Town & Country Planning (Control of Advertisement) (England) Regulations 2007 (as amended)

Application for Consent to Display an Advertisement(s)

Development: See Application Form
Location: 230 Chichester Road Bersted PO21 5BA

DRAWING TITLE
ELEVATIONS

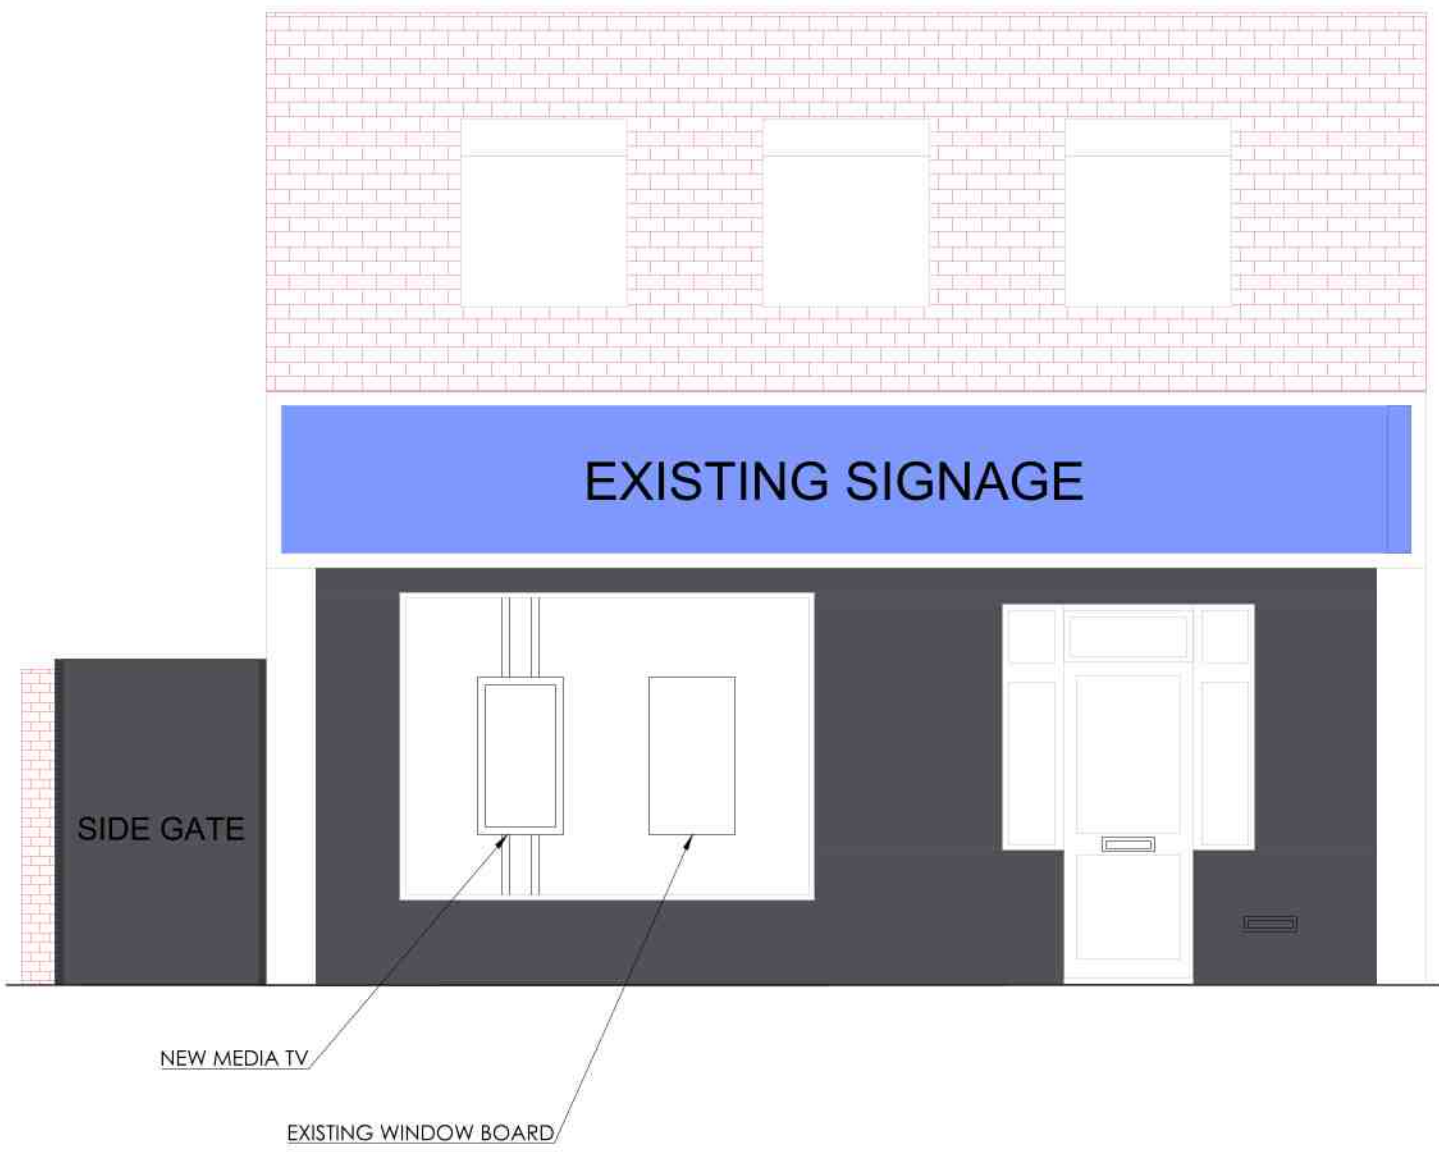
Plans

Please submit clearly labelled plans of the proposed signage at a scale of 1:50 or 1:100. Further details can be found in the Validation Requirements List.
